Project Title: Caliber's Shooting Range

Re: Caliber's Shooting Range, 4340 Cutler Ave. NE
Request For Permanent C.O.
Engineer's Stamp Dated: 02-05-13 (H17/D089A)
Certification dated: 08-30-13

**RE: CALIBER'S SHOOTING RANGE, 4340 CUTLER AVE. NE
ENGINEER'S STAMP DATED 12-18-2012 (H-17/D089A)**

Re: Caliber's Shooting Range, 4340 Cutler Ave. NE
Engineer's Stamp dated 12-18-2012 (H-17/D089A)

DRAWN BY
pm
DATE
11-29-12
2012090-GRB.DWG
SHEET #
C101
JOB #
2012090

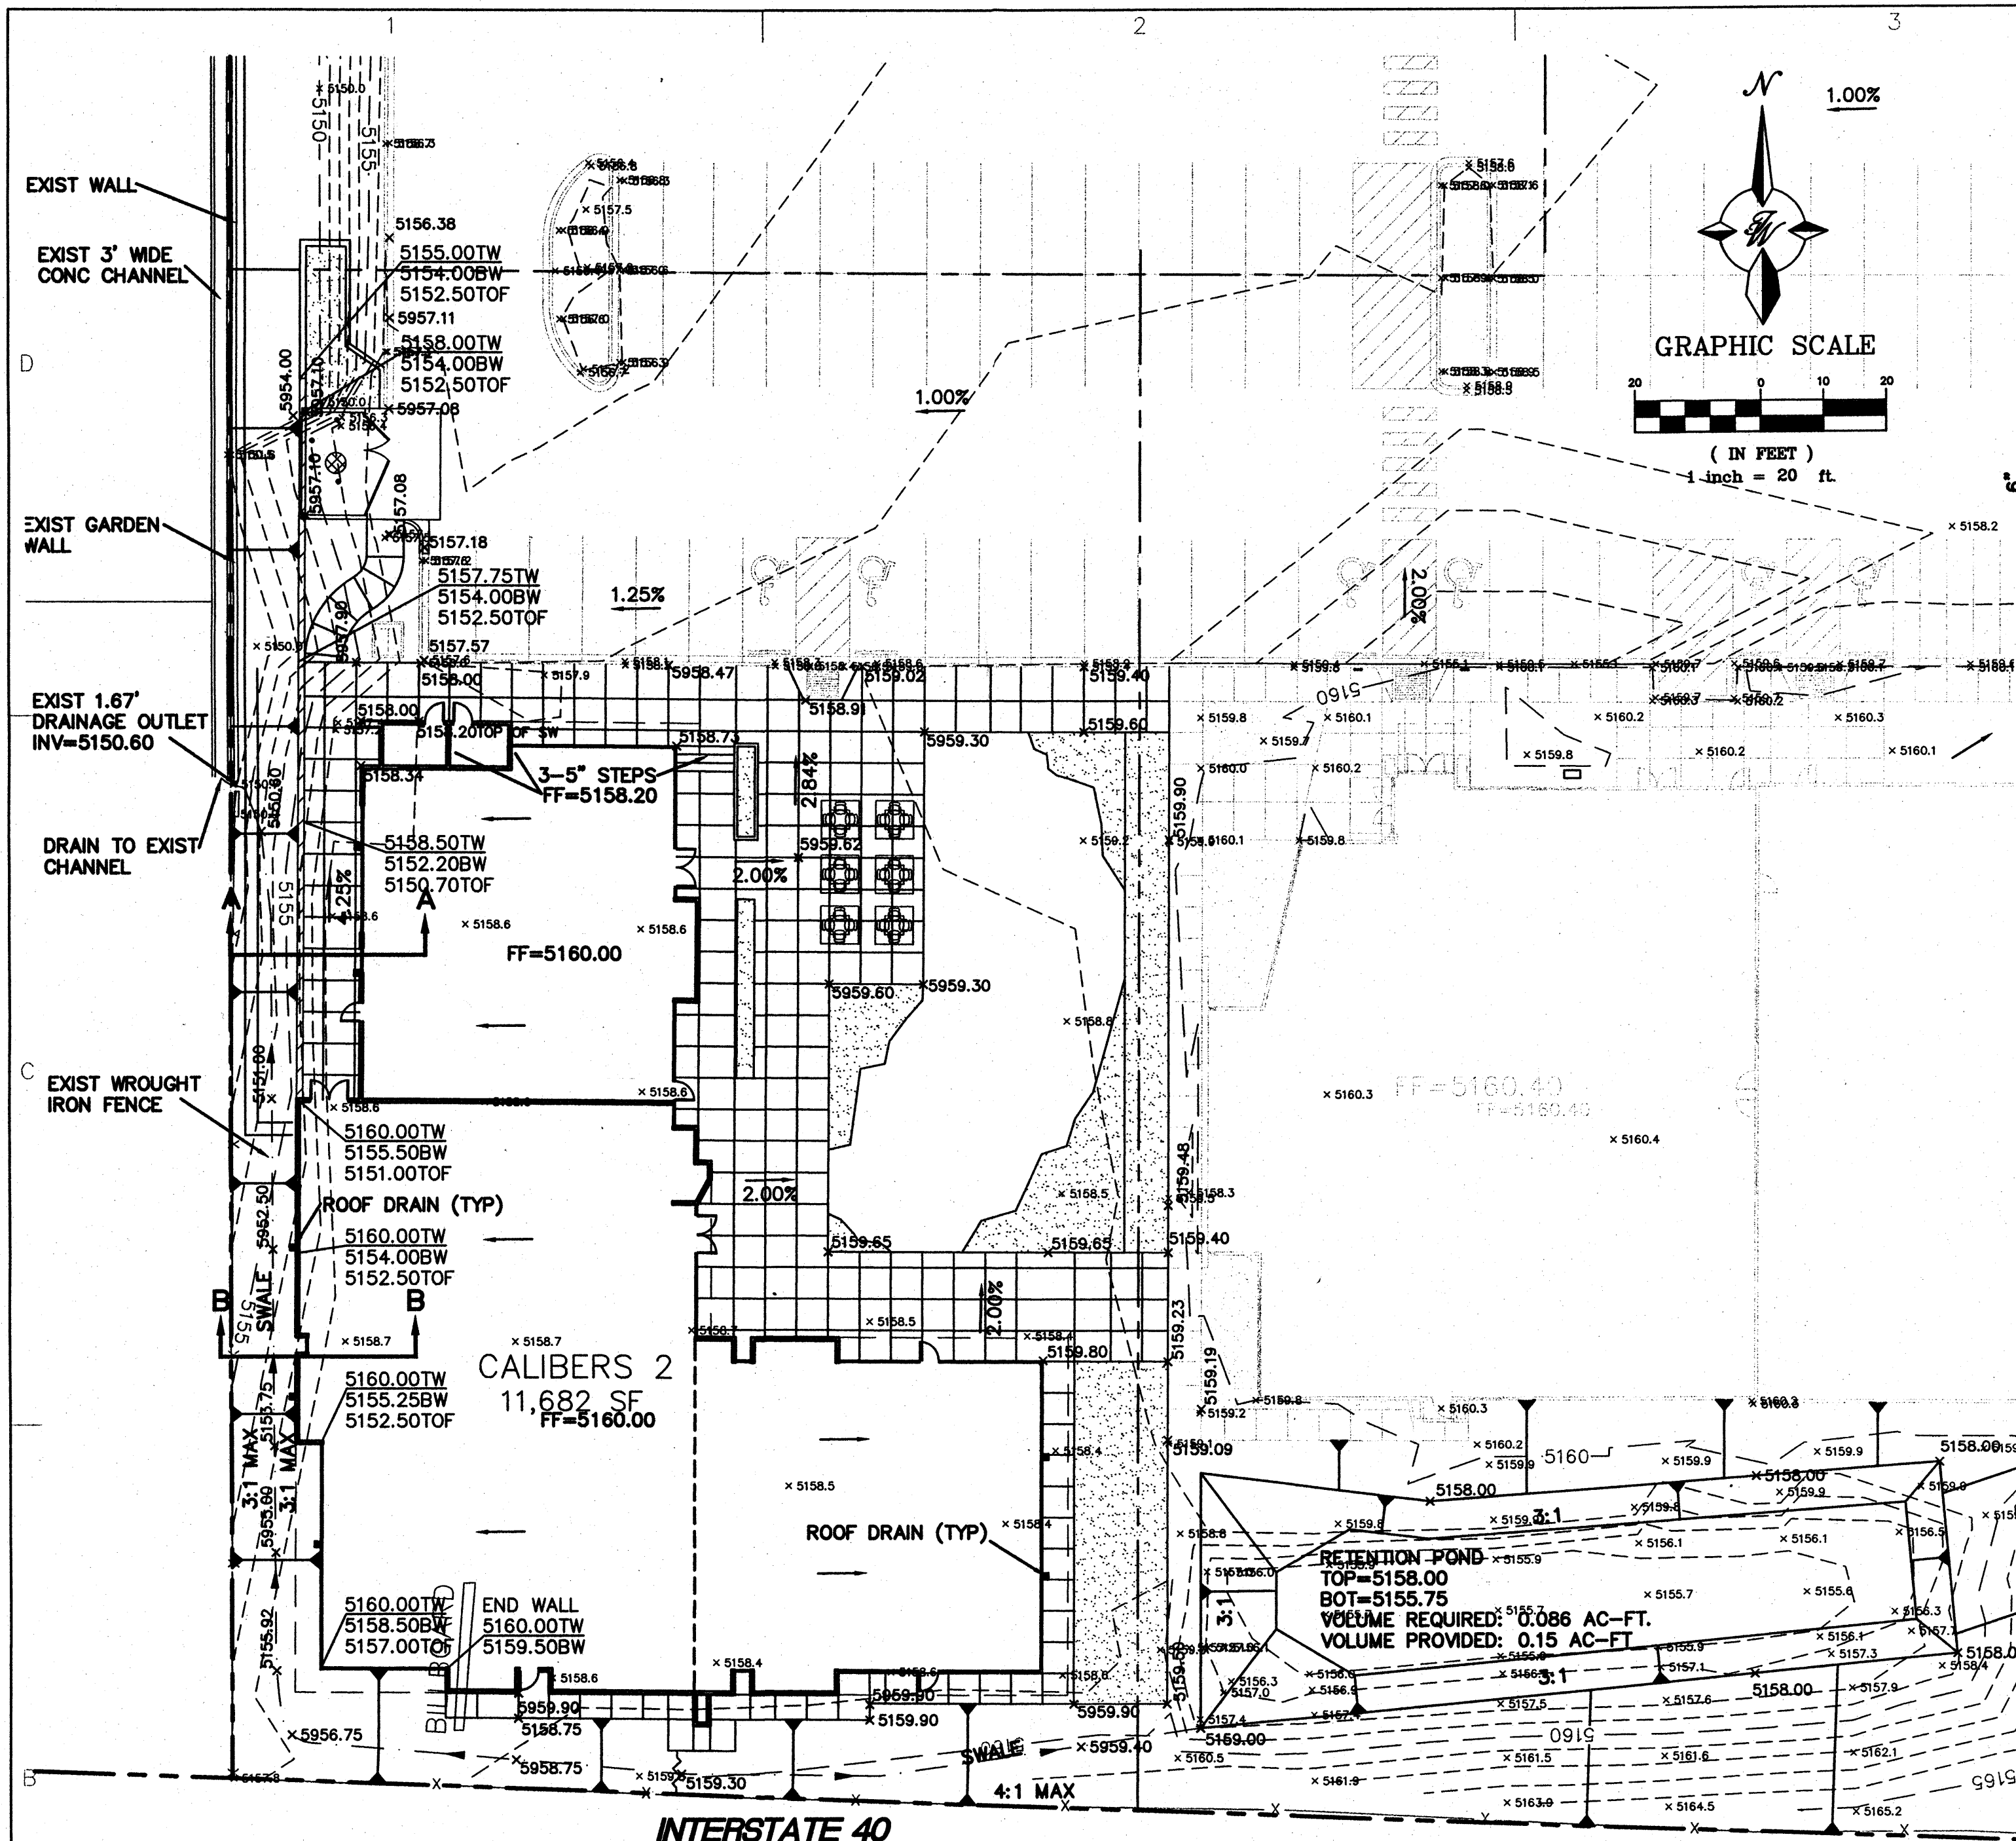
1. The proposed grading and placement of cobbles along the western property line encroaches upon the adjacent lot. A written agreement from this lot's owner will be needed before this work can be approved.

2. The southern swale in Basin 4 appears to be directed in a concentrated flow towards the neighboring property line; will a cobble swale be required at this location as well?

3. Please provide a note or a detail for the proposed 10' cobble swales.

4. A portion of Basin 4 that was originally included in it's calculations along the west entrance to the northernmost building appears to now outfall into Basin 1 and should not be included in Basin 4's flows.

5. Section A-A and B-B might need to be changed based on the response of the adjacent lot's property owner.

The same person owns both tracts and a letter is enclosed stating permission is granted to grade on that parcel.

That swale was directed to the first cobble swale and clarified on the plan.

A detail of the cobble swale was added to the plan.

We reviewed the plan and the Basins accurately reflect how the storm water is draining on the site.

As stated above, the adjacent property owner has given permission to grade on his tract.
